Response to TOA Comments – 23–31 Dover Road, Rose Bay

We are writing on behalf of Dover Street (Rose Bay) Developments Pty Limited (**the proponent**) in respect of the State Significant Development application (**SSDA**) (SSD- 86017721) for an in-fill affordable housing development at 23–31 Dover Road, Rose Bay (**the project**).

This information is submitted in response to the Request for Additional Information (**RFI**) issued by the Department of Planning, Housing and Infrastructure (**DPHI**) via email on 11 March 2026.

DRAWING TITLE:
BASEMENT 02 FLOOR PLAN

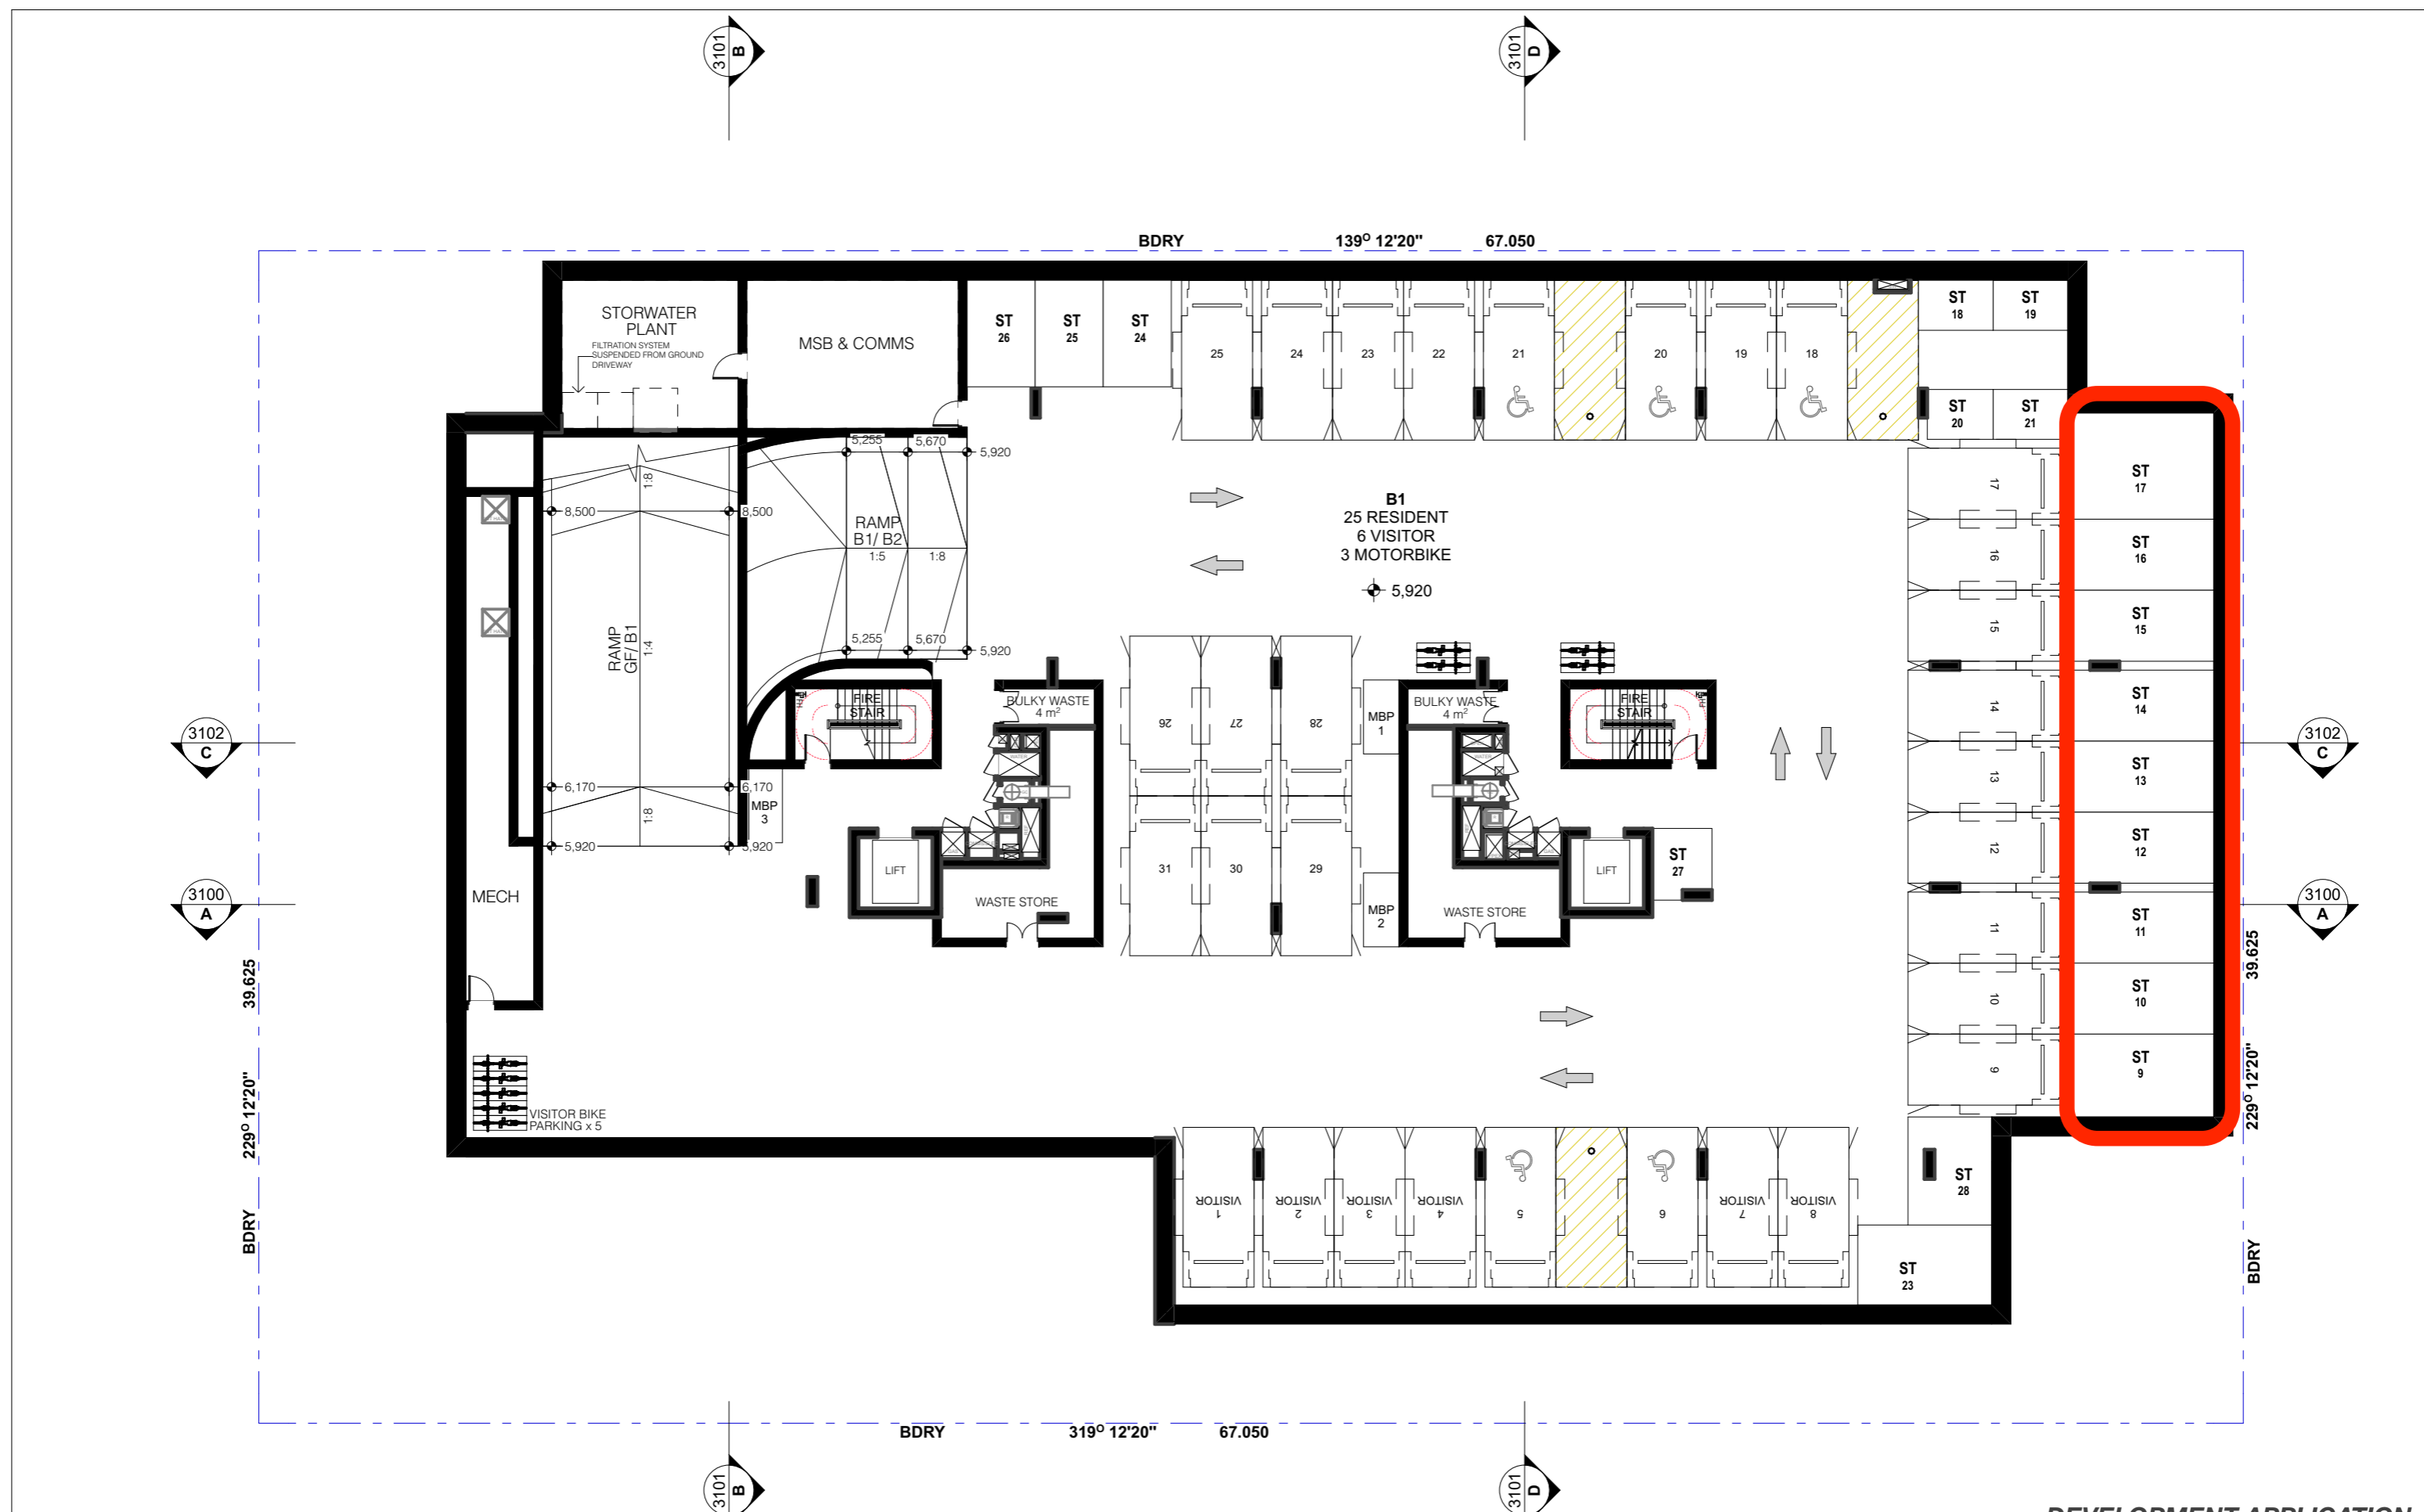
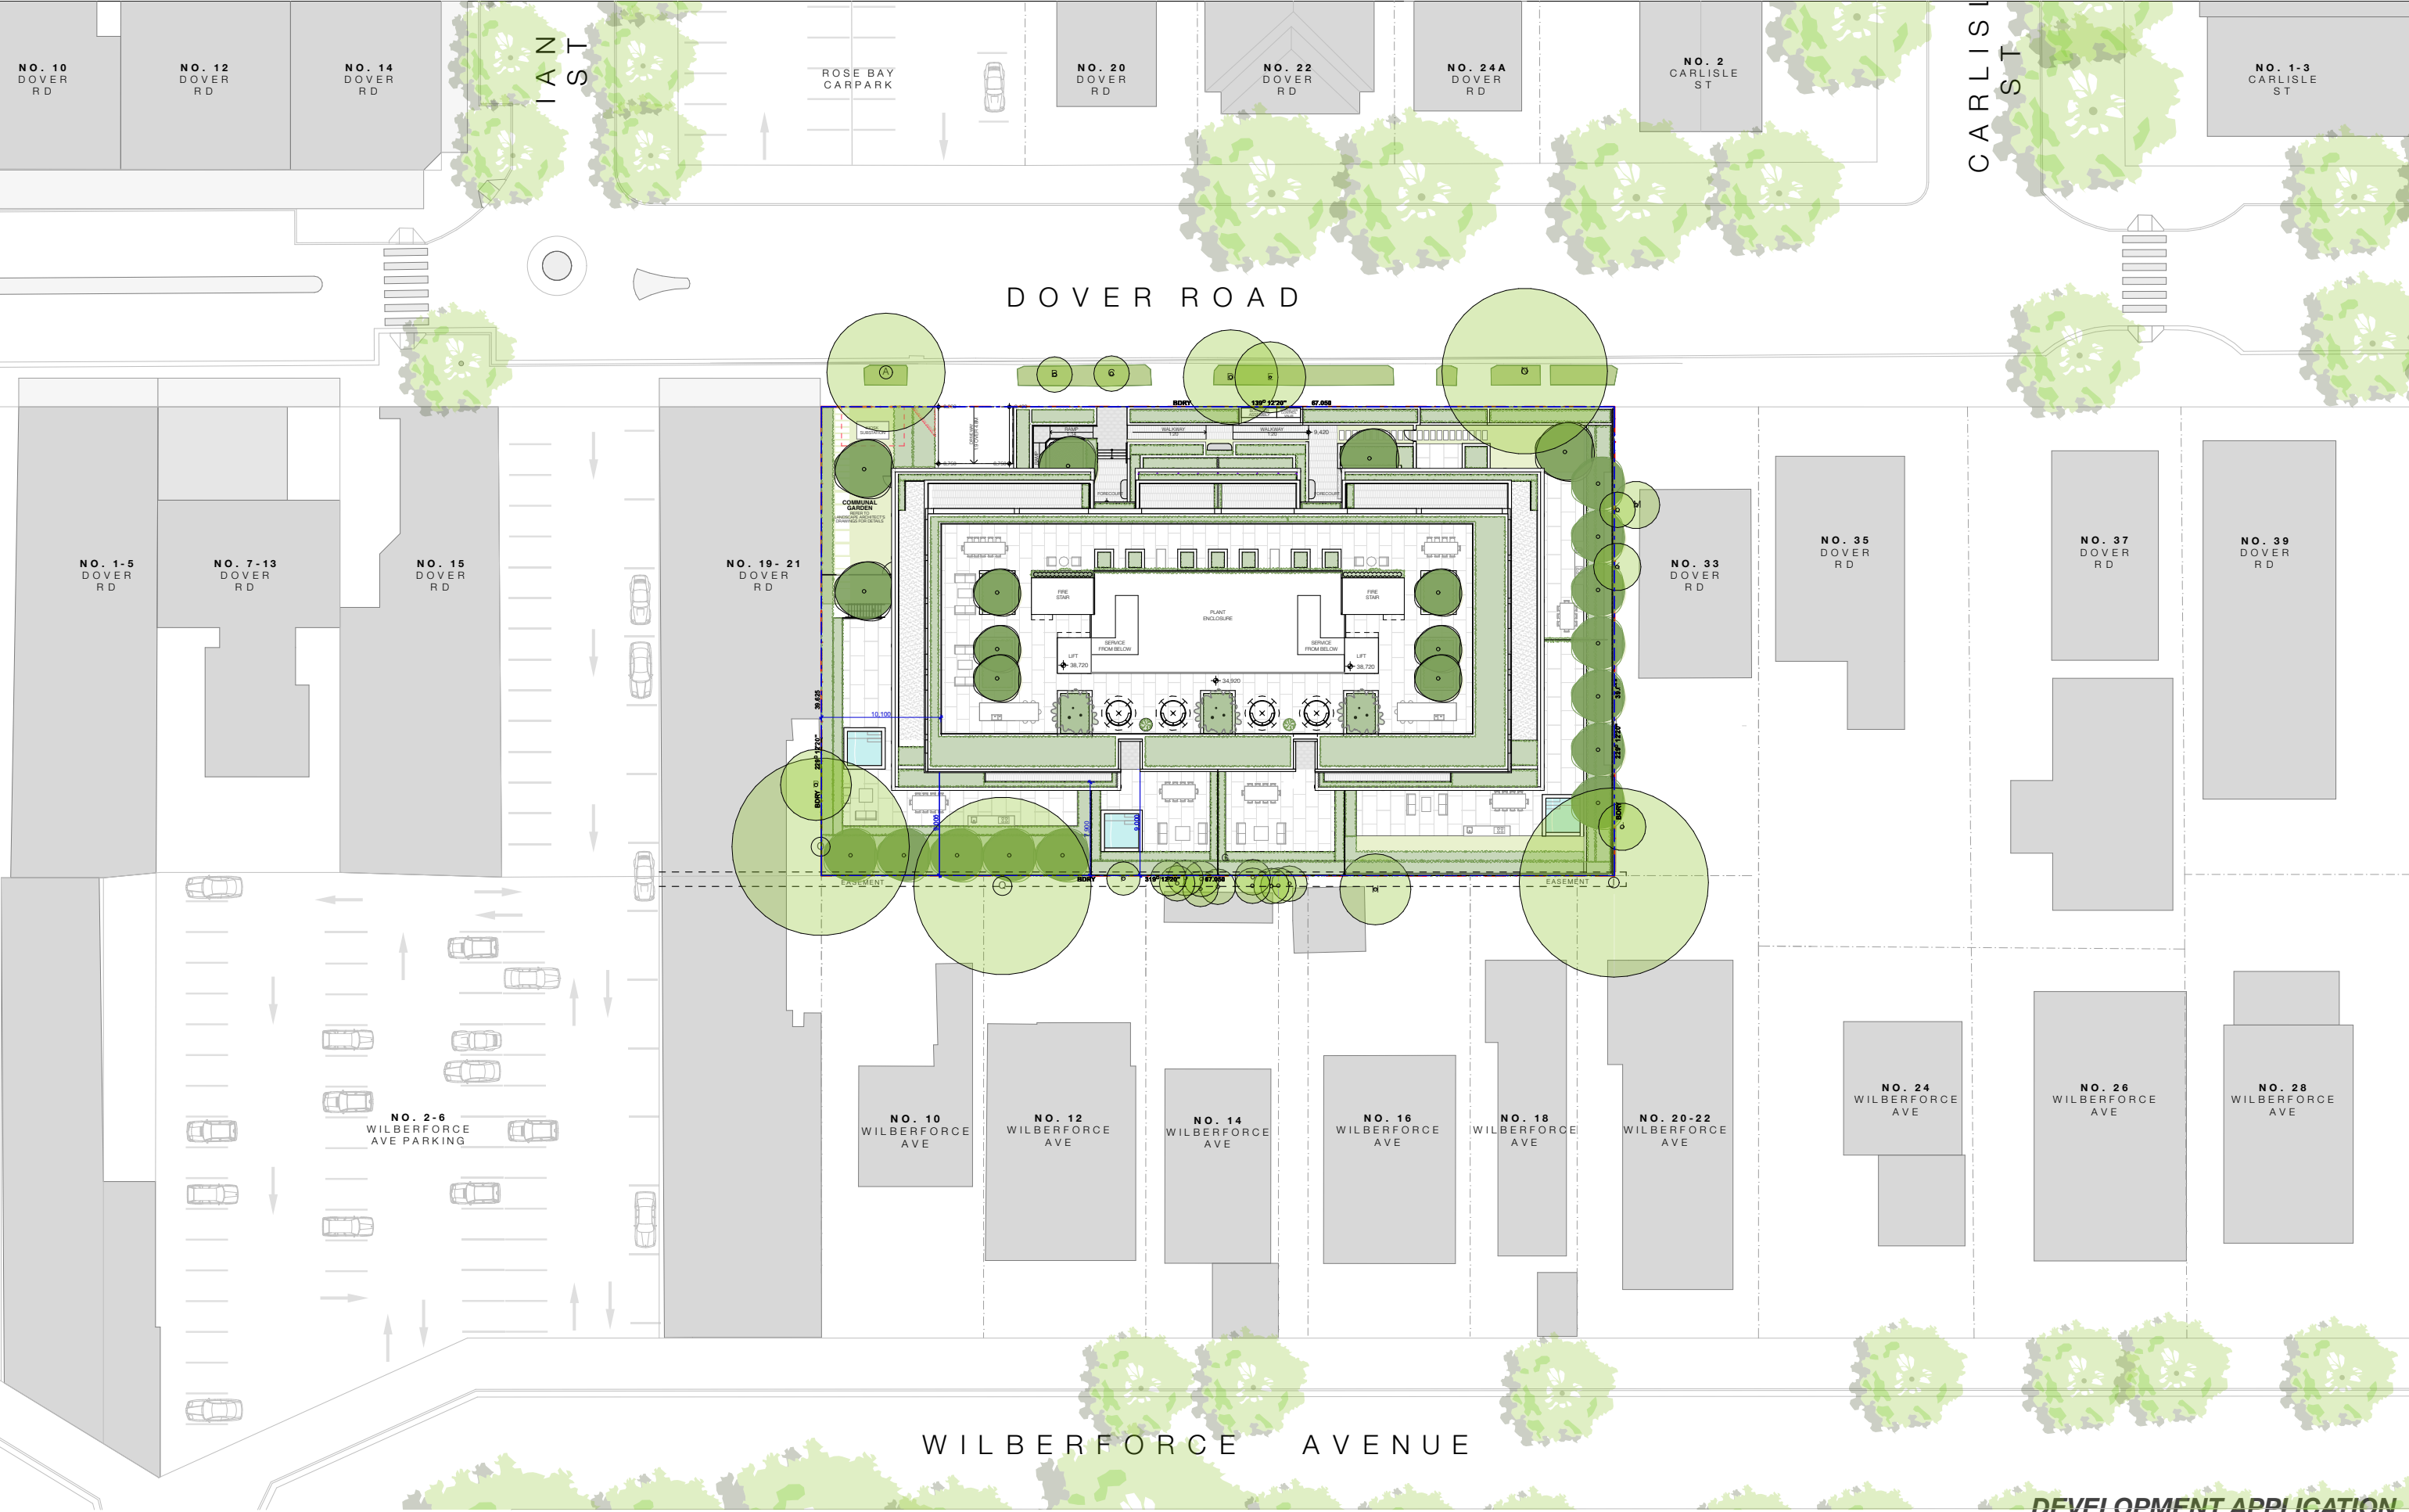
DPHI Query	Status
1. The Department has concerns over the size of the storage spaces provided on the basement levels especially on the eastern side of the basement. Due to the storage sizes the development does not have side setbacks/ deep soil along the eastern property boundary. The Department notes that the Applicant has advised	The storage space is not causing the size of the basement, the basement structure relates to the safest and most efficient way of constructing on that boundary, given the required retaining way and associated structural integrity. An amended design is proposed for the basement to help address the DPHI's comments. The footprint of basement level 1 and basement level 2 has been reduced by pulling back the eastern corner from 5,280m to 10,128m and 4,834m to 5,525m, as per the below:

that basement redesign is not a feasible option and will require additional excavation, however looking at the storage sizes recommended in the ADG, the storage areas can be resized to comply with the ADG requirements. Units 14 – 22 and 34 – 42 have approximately 26sqm of storage which can be reduced whilst still providing room for bicycle storage.

This results in a reduction from 1,823 m² to 1,792 m² internal building footprint area in the basements.

A full re-design of the basement and setback along the full extent of the south-eastern boundary is not feasible. Further reductions in the basement floor plate will have an adverse impact on the structural integrity of the building, significantly constrain vehicle circulation and parking efficiency, and compromise compliance with minimum access, safety, and service requirements.

3 LEVEL 6 - AFFORDABLE HOUSING

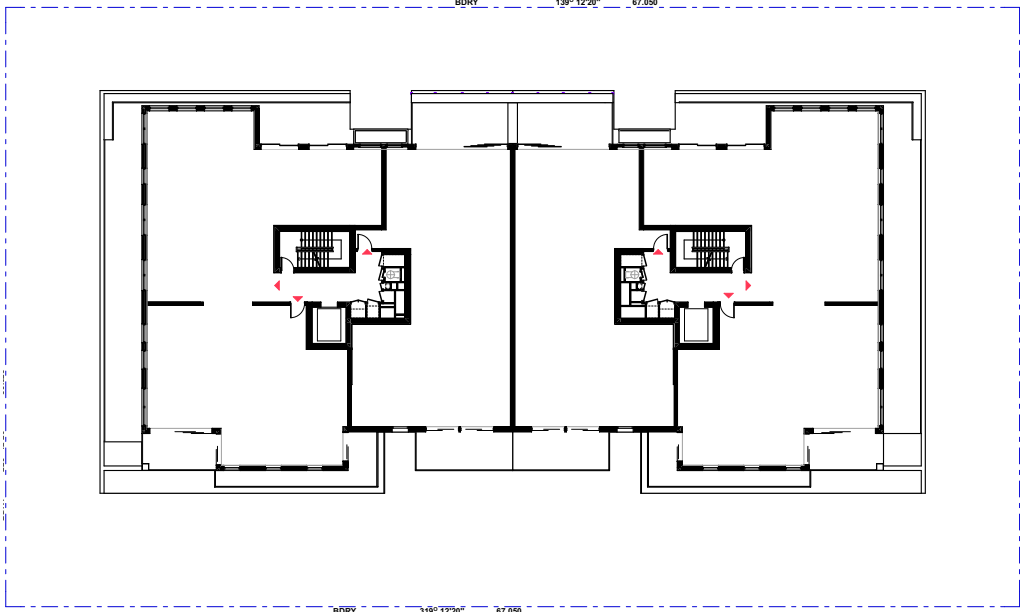
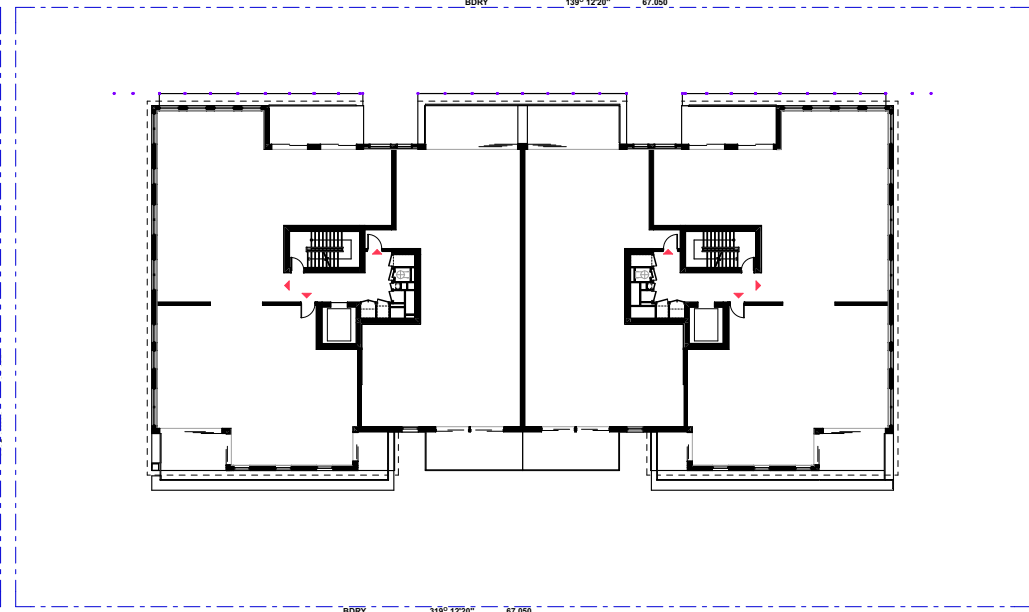
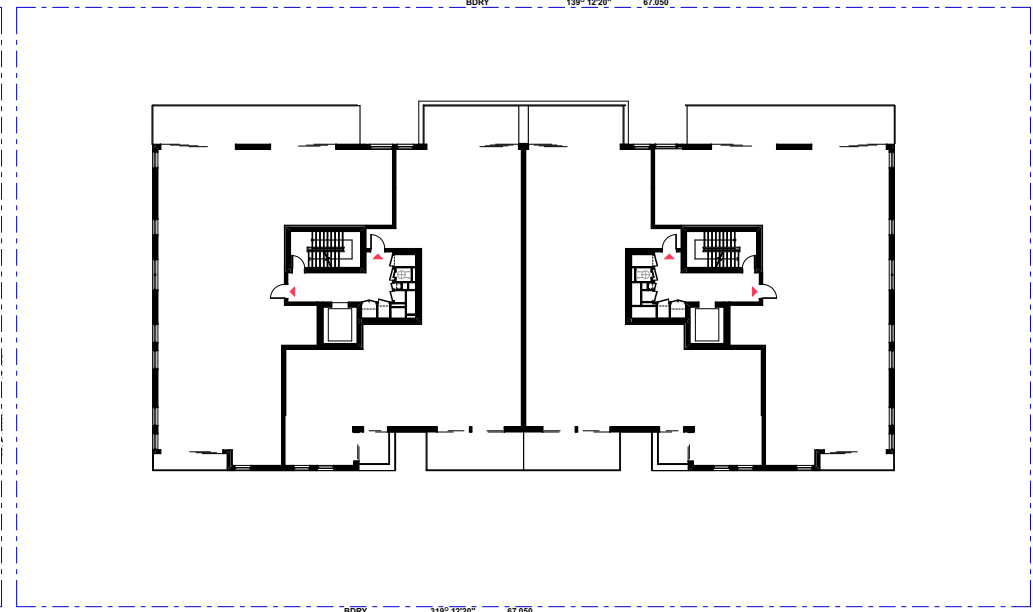
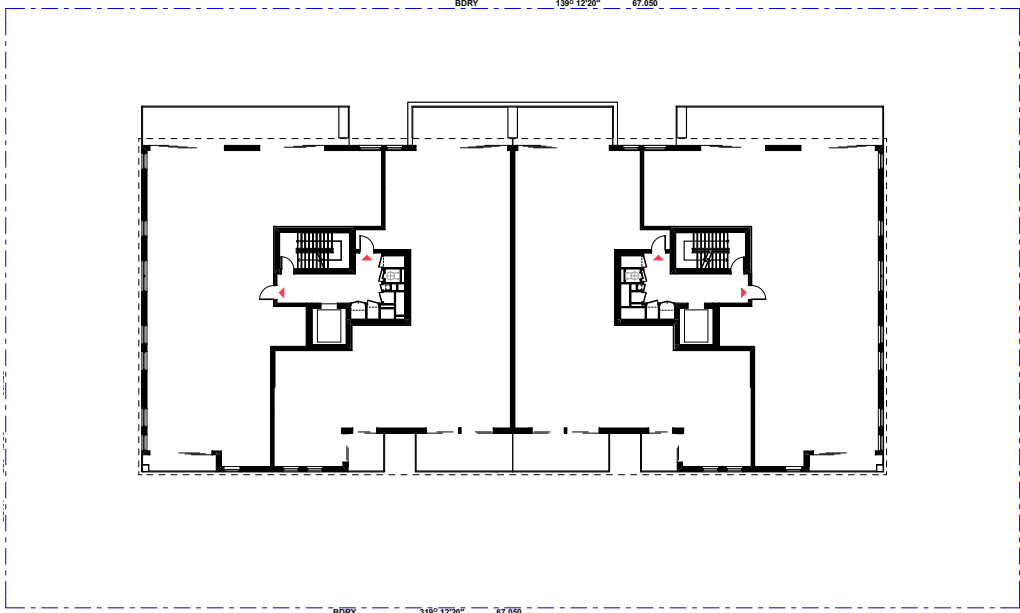
2. Unit numbers and storage size for Level 6 is missing on drawing 9104, please update.

Architectural Plans have been updated.
